# CITY OF ALBUQUERQUE

September 4, 2018

**Re: Winfield TI**  
**7501 Meridian Place, NW Suite B- 1**  
**Traffic Circulation Layout**  
Engineer's/Architect's Stamp **07-25-18 K10-D023G)**

4 HANDICAP PARKING SIGN
1"=1'-0"

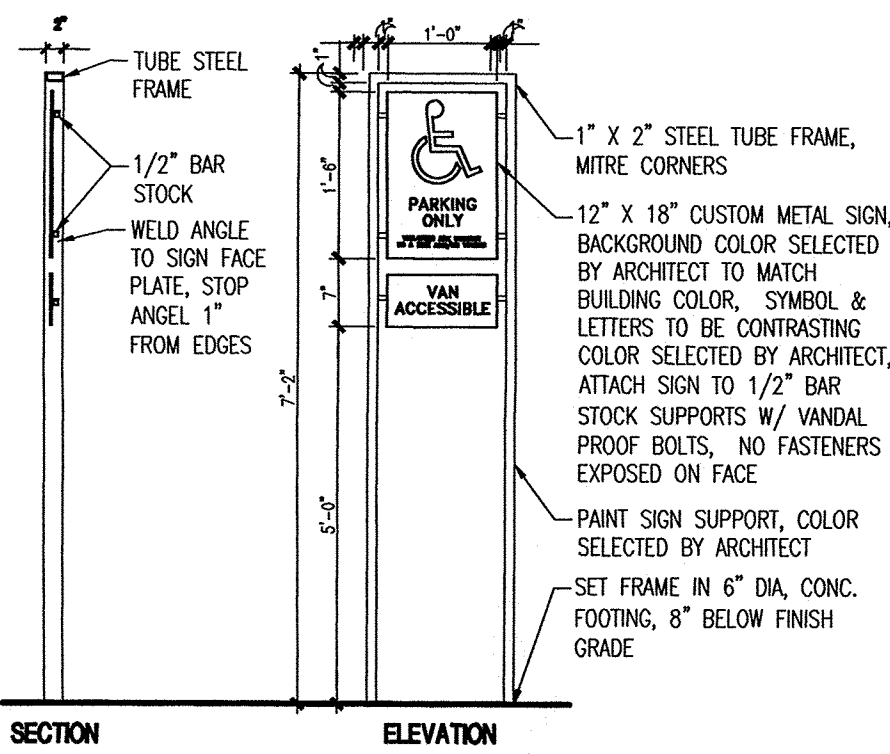
4. The ADA accessible parking sign must have the required language per 66-7-352.4C NMSA 1978 **"Violators Are Subject to a Fine and/or Towing."** Please call out detail and location of HC signs.

2 ACCESSIBLE PARKING
1"=1'-0"

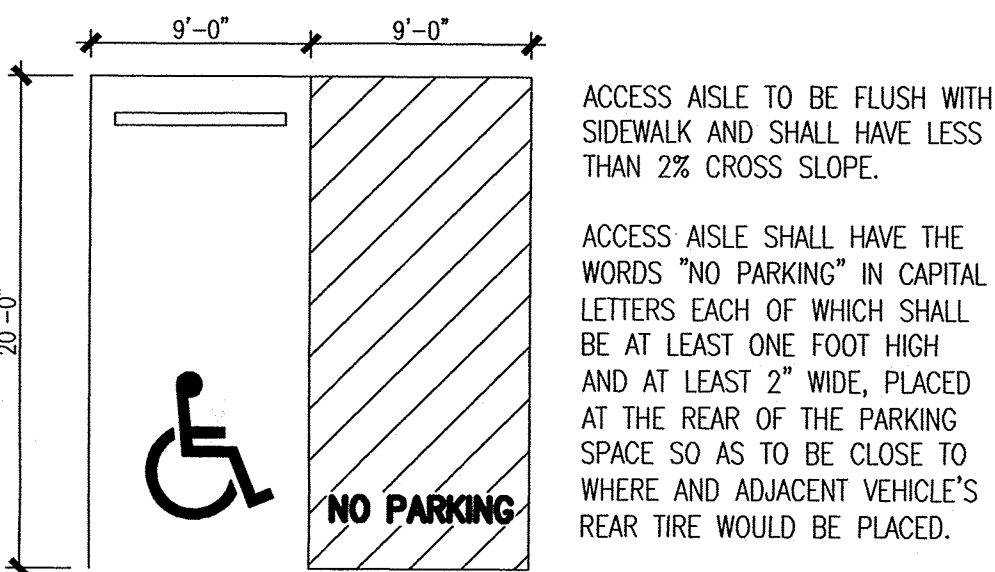
5. The ADA access aisles shall have the words **"NO PARKING"** in capital letters, each of which shall be at least one foot high and at least two inches wide, placed at the rear of the parking space so as to be close to where an adjacent vehicle's rear tire would be placed. (66-1-4.1.B NMSA 1978)

1 SITE PLAN
1"=30'

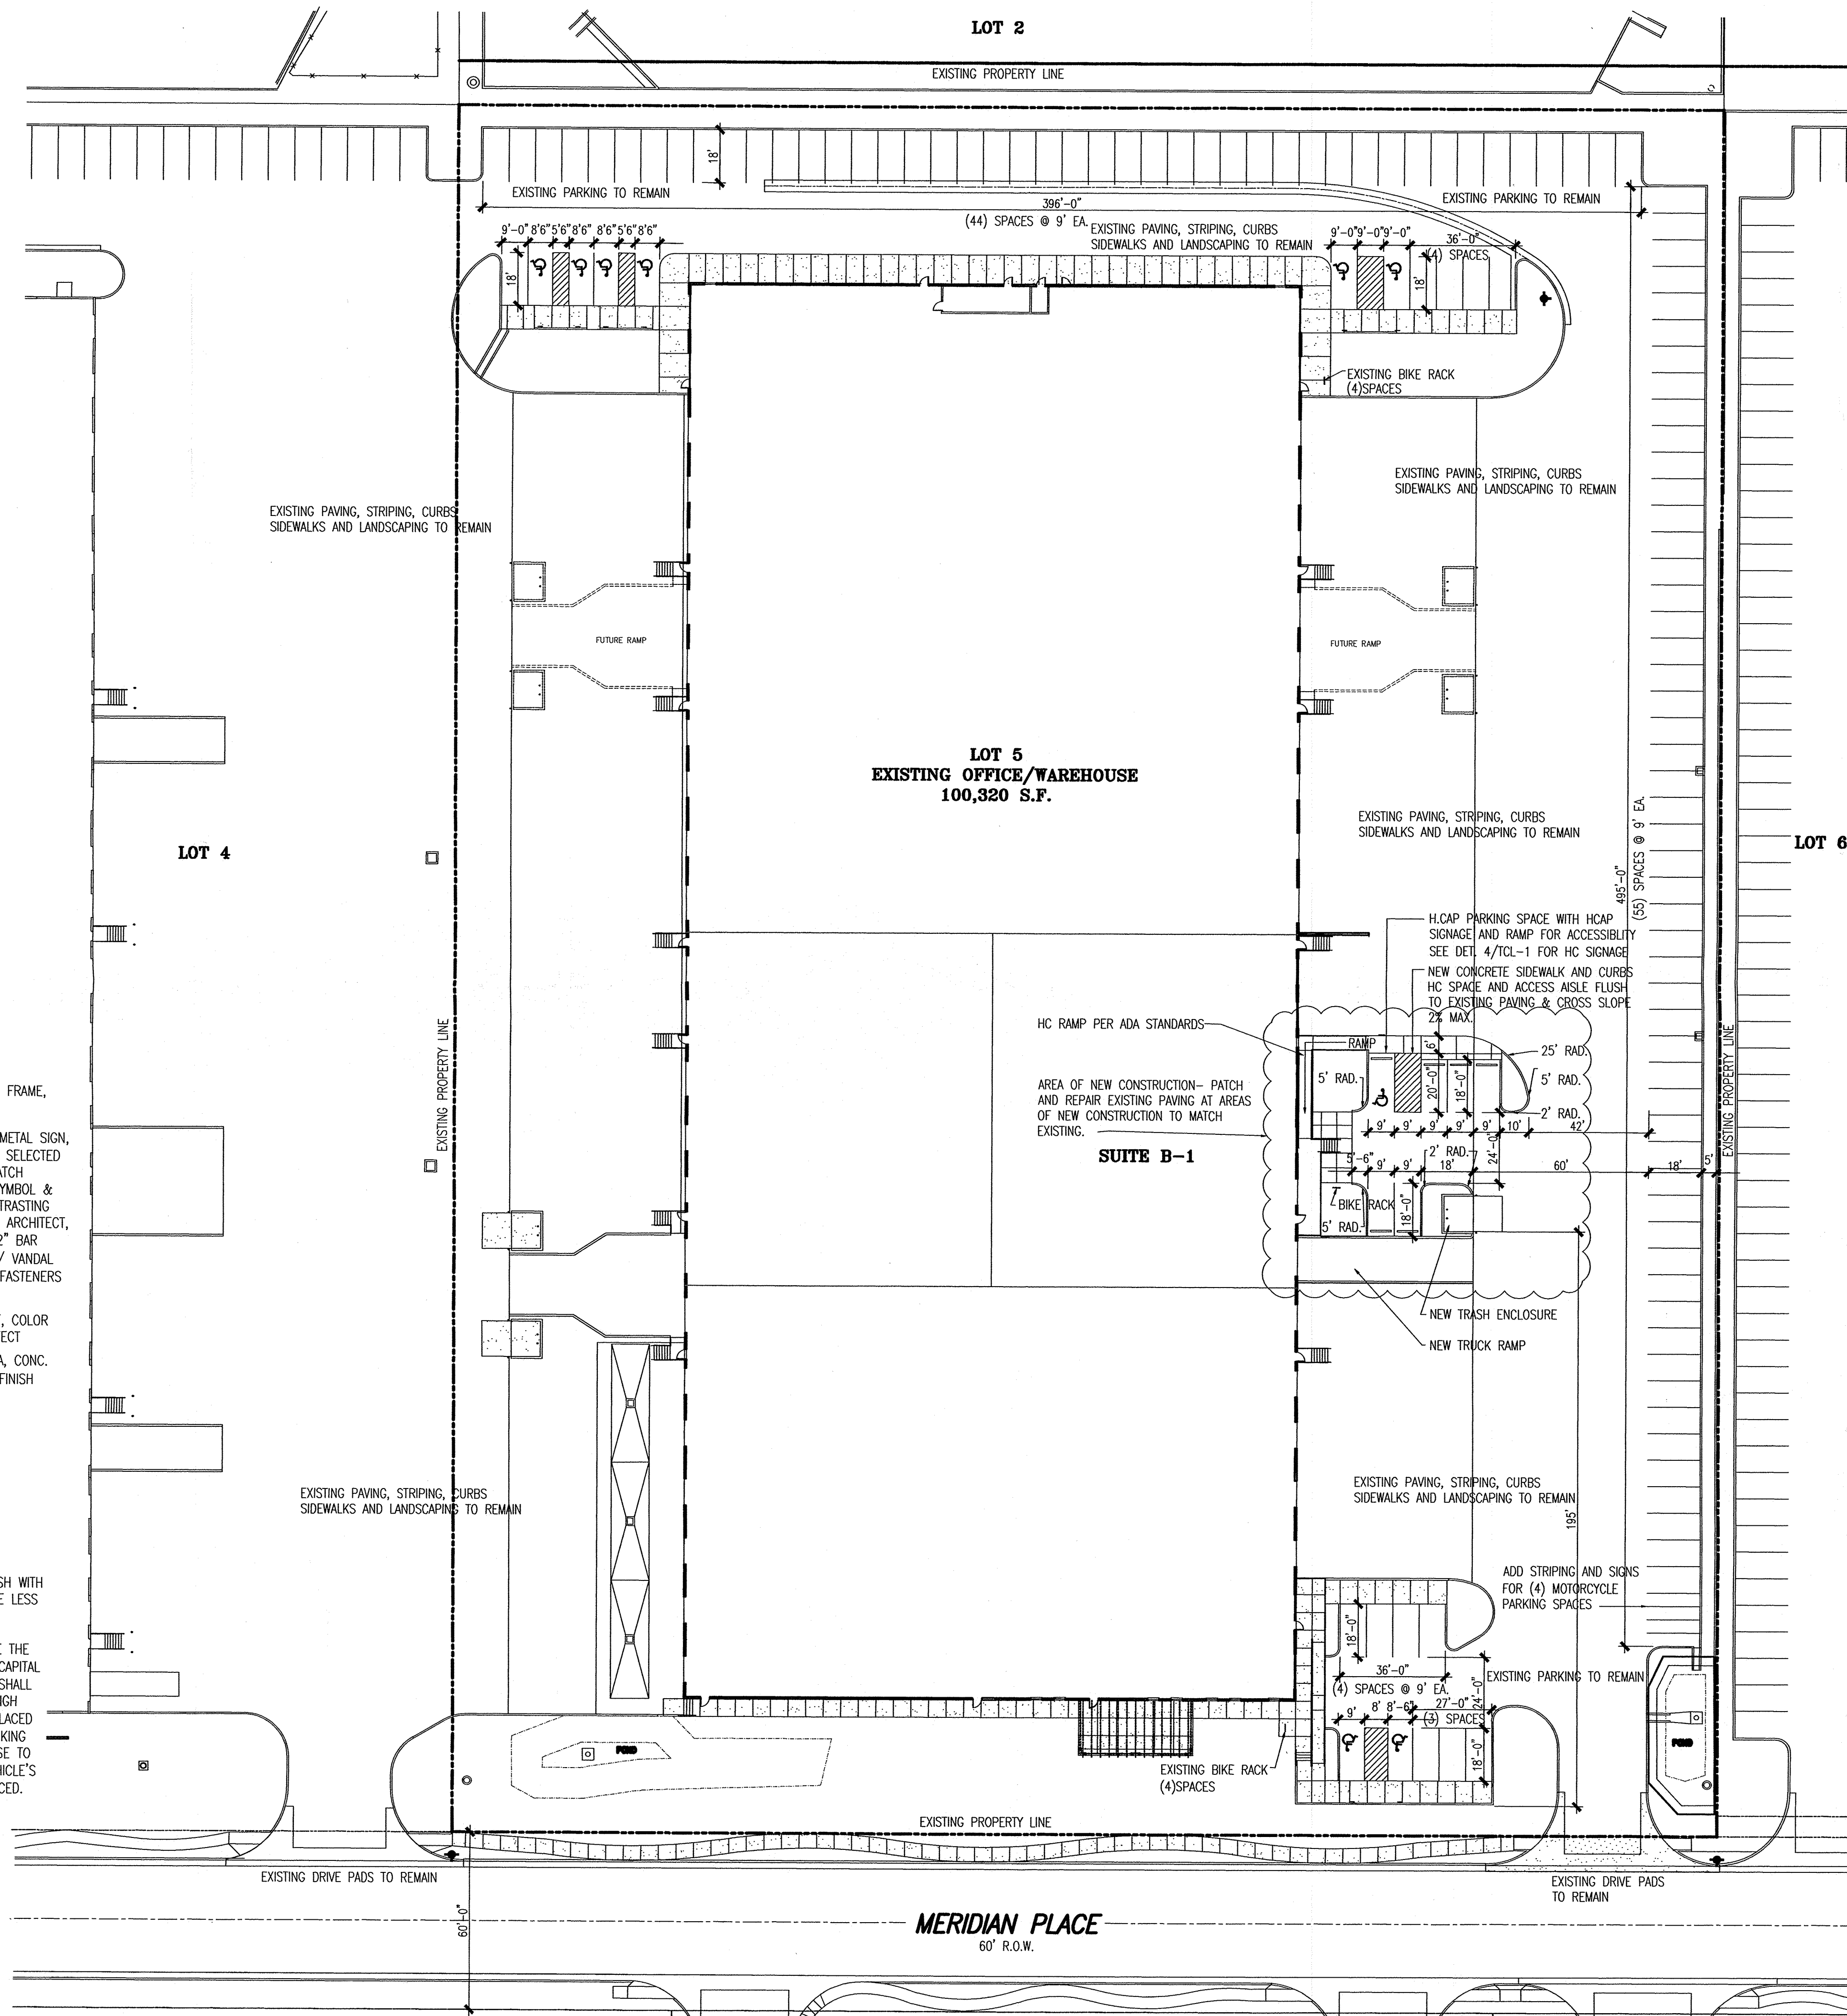
1. Please review and revise plan to provide all information listed on the attached Traffic Circulation Layout checklist and submit a TCL for the whole site.

2. Please show a vicinity map showing the location of the development in relation to streets and well known landmarks.
3. List the number of parking spaces required by the zoning code as well as the proposed number of parking spaces including bicycle and motorcycle parking.
